**Our Ref: XA/2025/100350/07
Your Ref:
Date: 29/04/26**

SEA LINK, EAST ANGLIA AND KENT

ENVIRONMENT AGENCY RESPONSE FOR DEADLINE 7.

Plate 2.3 Infrastructure within fluvial flood extents

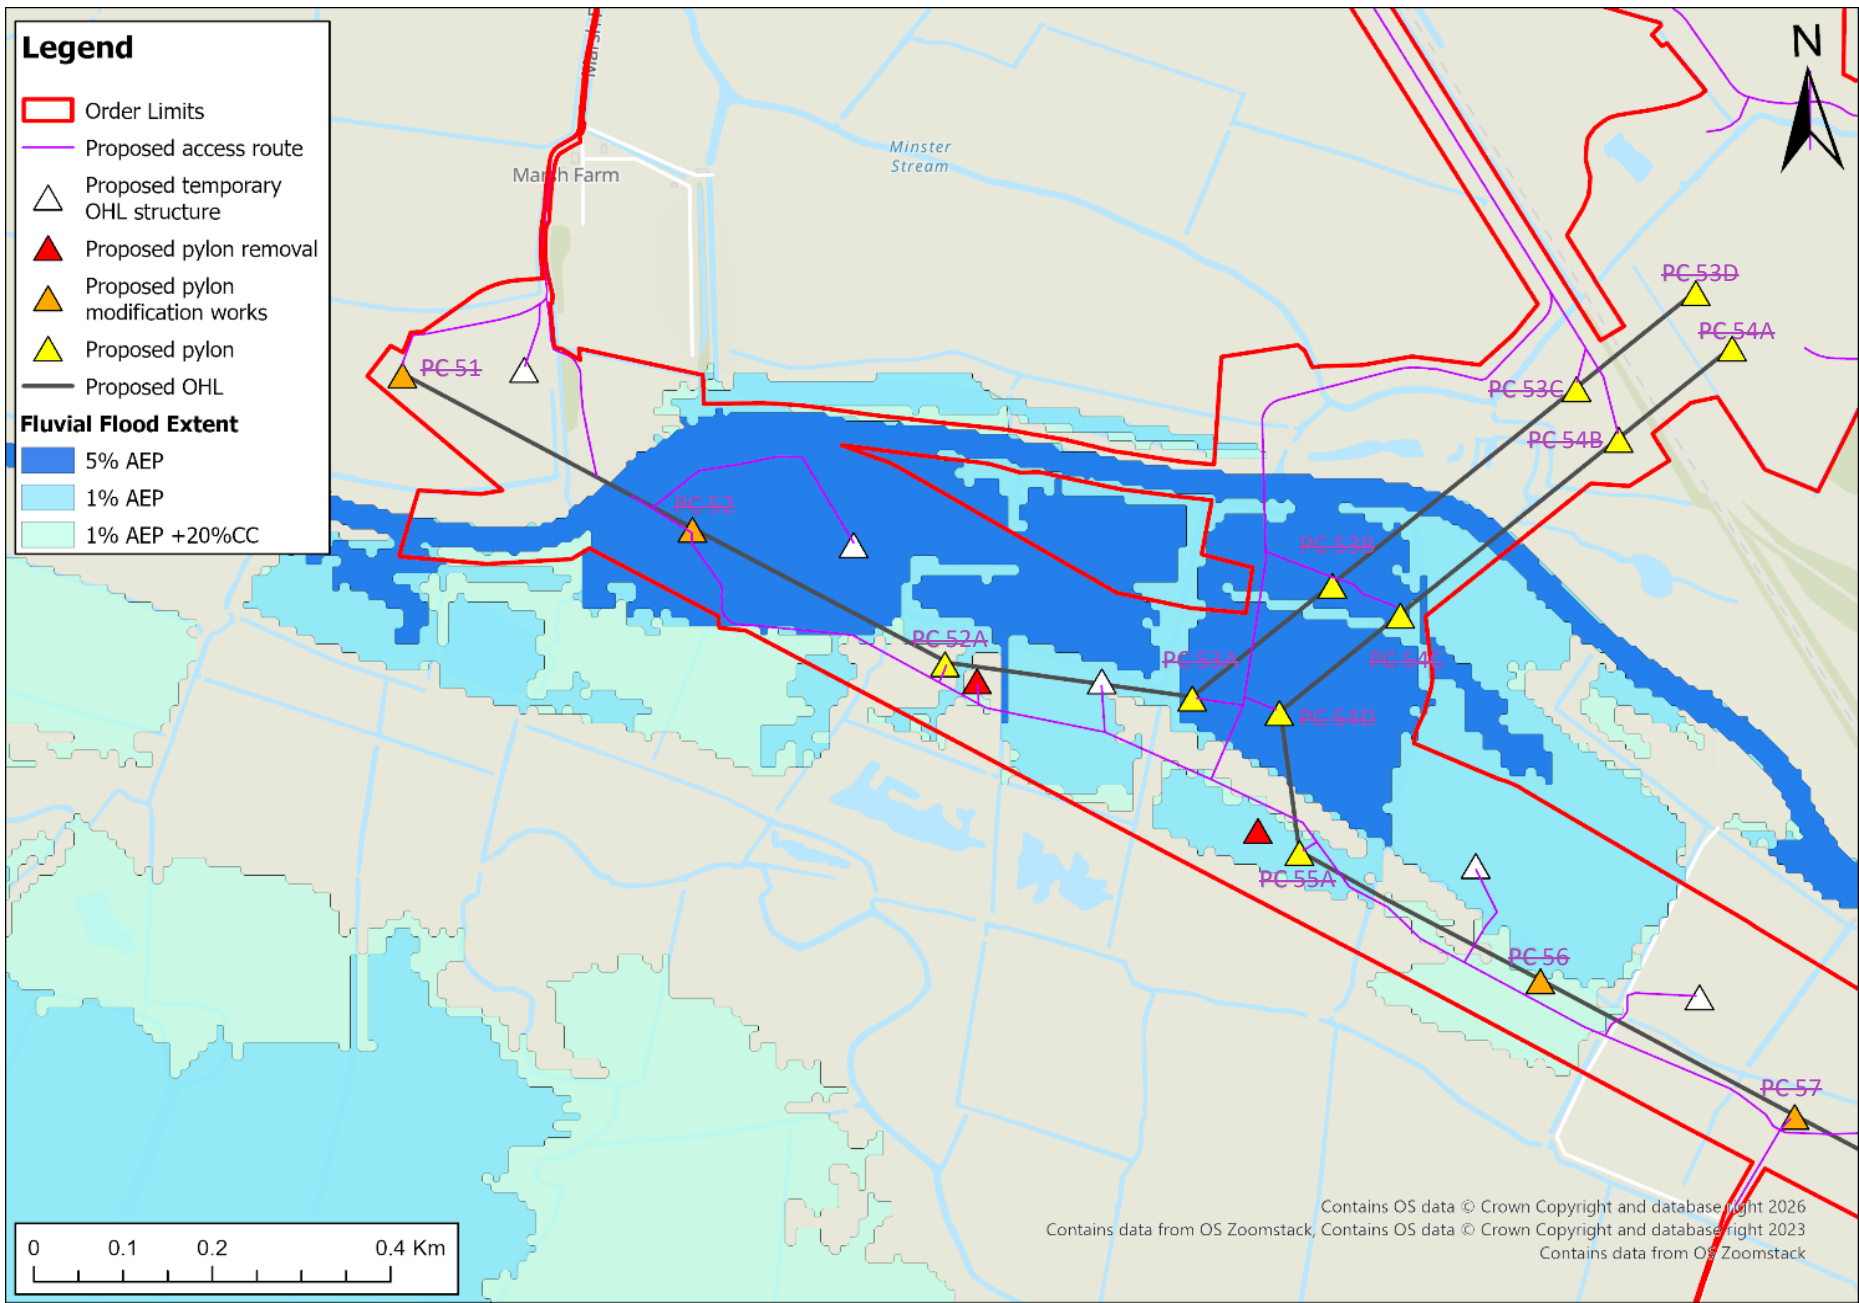
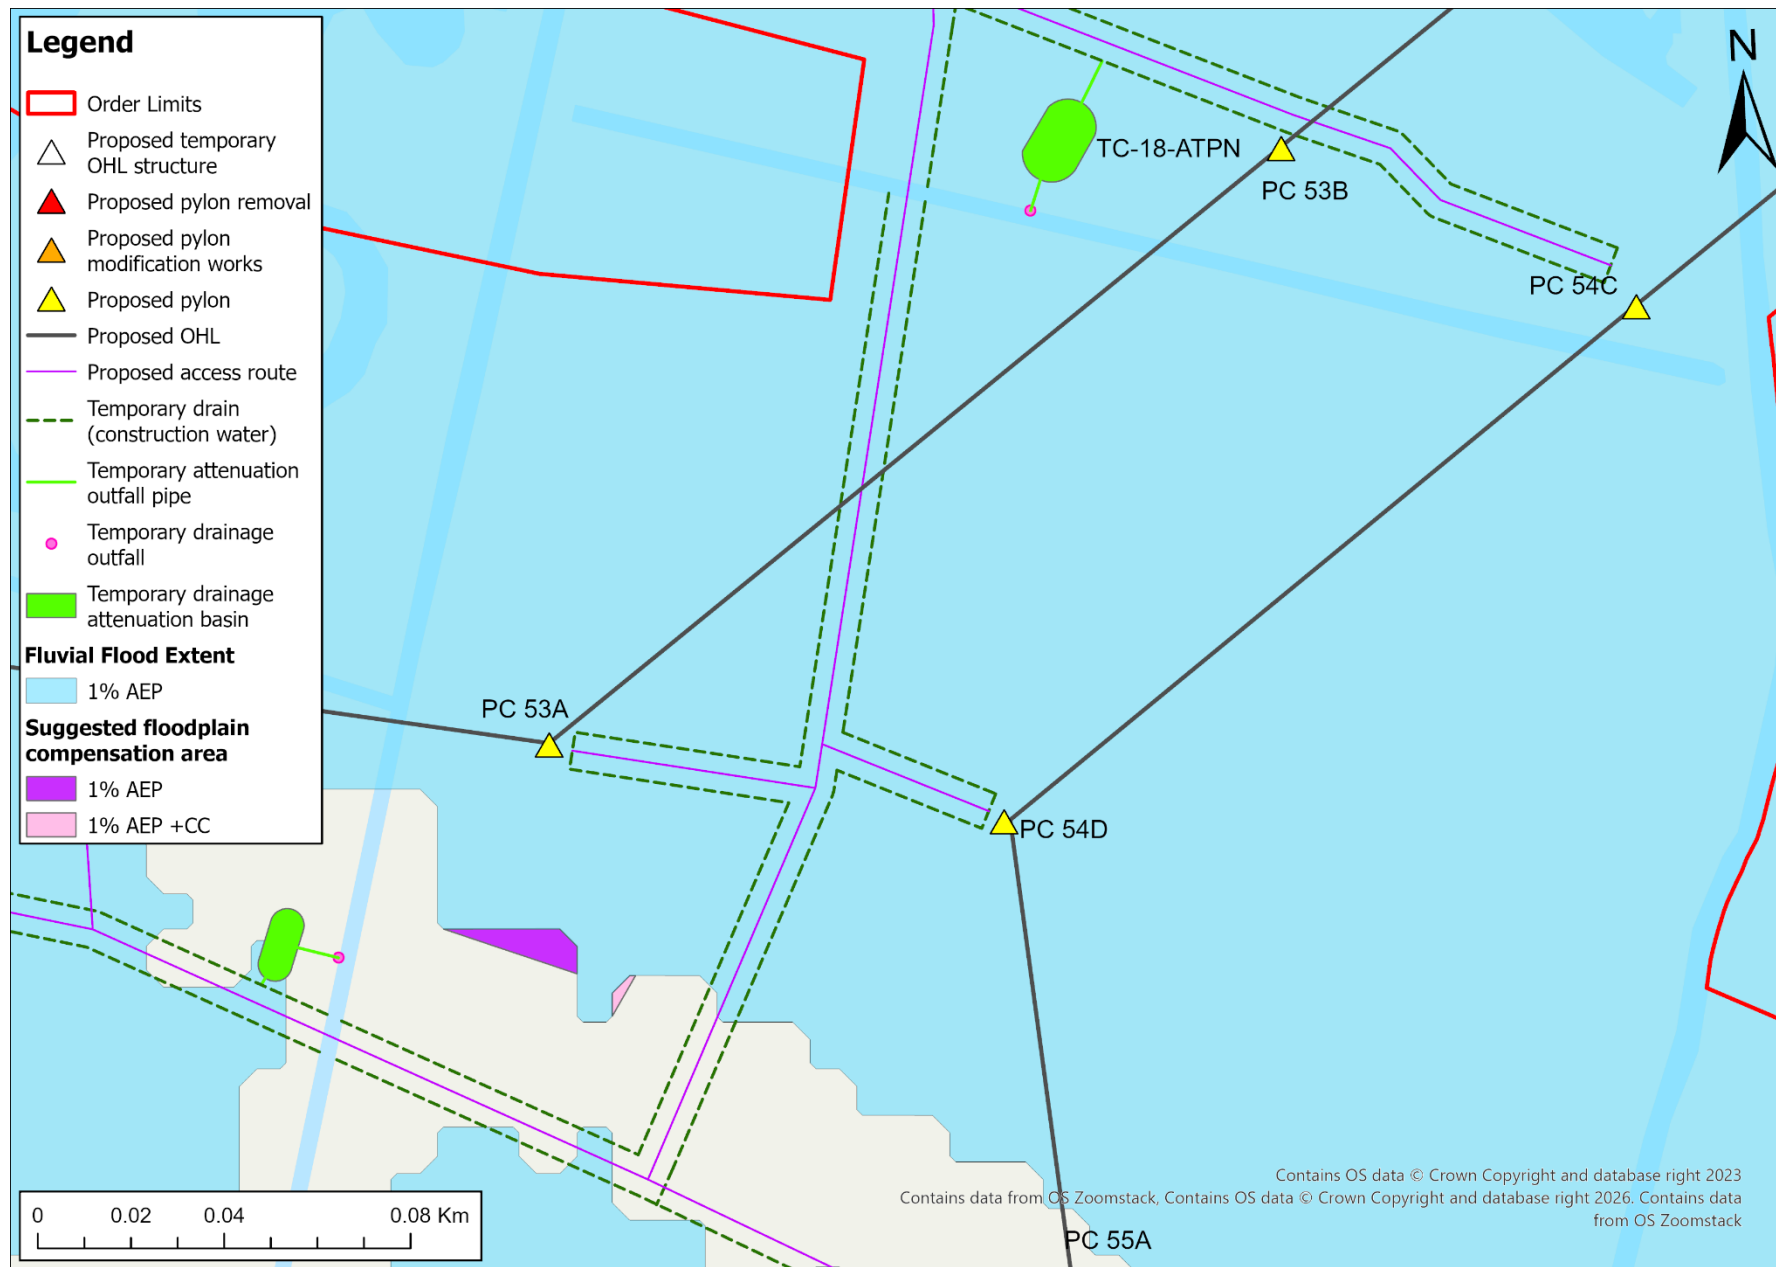
Issue	Details omitted regarding temporary attenuation ponds and outfalls within flood plain. Unknown construction method and details on the expected changes in ground level in order to construct these temporary features.
Impact	Changes in ground level to accommodate any attenuation basins may increase flood risk.
Solution	<p>Details of attenuation ponds and construction methods including whether any changes to ground level are required to be submitted and reviewed. These details should be included in the CEMP.</p> <p>Changes in ground level to accommodate any attenuation basins, must be carefully designed to mitigate impacts of loss of flood storage and changes in flow path. Please see the additional comments below:</p>

There is no mention of expected changes in ground levels in order to construct the attenuation basin, particularly relating to the "raised embankment". More detail regarding height and dimensions of this embankment in mAOD would be useful (for Kent only)

Figure 1: Location of the Fromus crossing and the potential flood risk to the western approach road

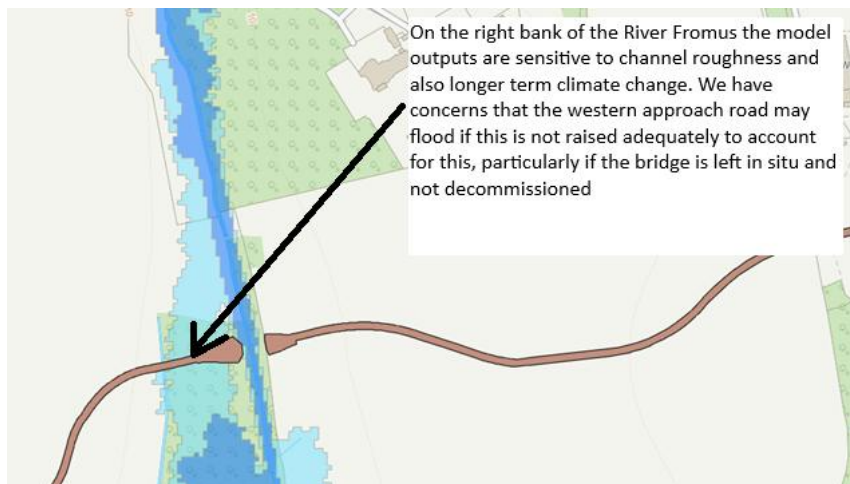
Document Reference(s): Relevant Representation EA081. REP6-052 Document 6.8 Flood Risk Assessment Version B	
Issue	Bridge may be retained after operation phase without adaptation plan for future flood risk.
Impact	Retained structure may limit floodplain function and increase climate change risk.
Solution	Applicant to include the +100mm raising of the Western Approach Road to the Fromus Bridge as a commitment. Please see the additional comments below for further details
We welcome the additional analysis that the applicant has undertaken with regards to the western approach road to the Fromus Crossing and the option to raise part of the approach road by 100mm to mitigate against flooding to the access ramp. We would like the applicant to include this +100mm raising as a commitment
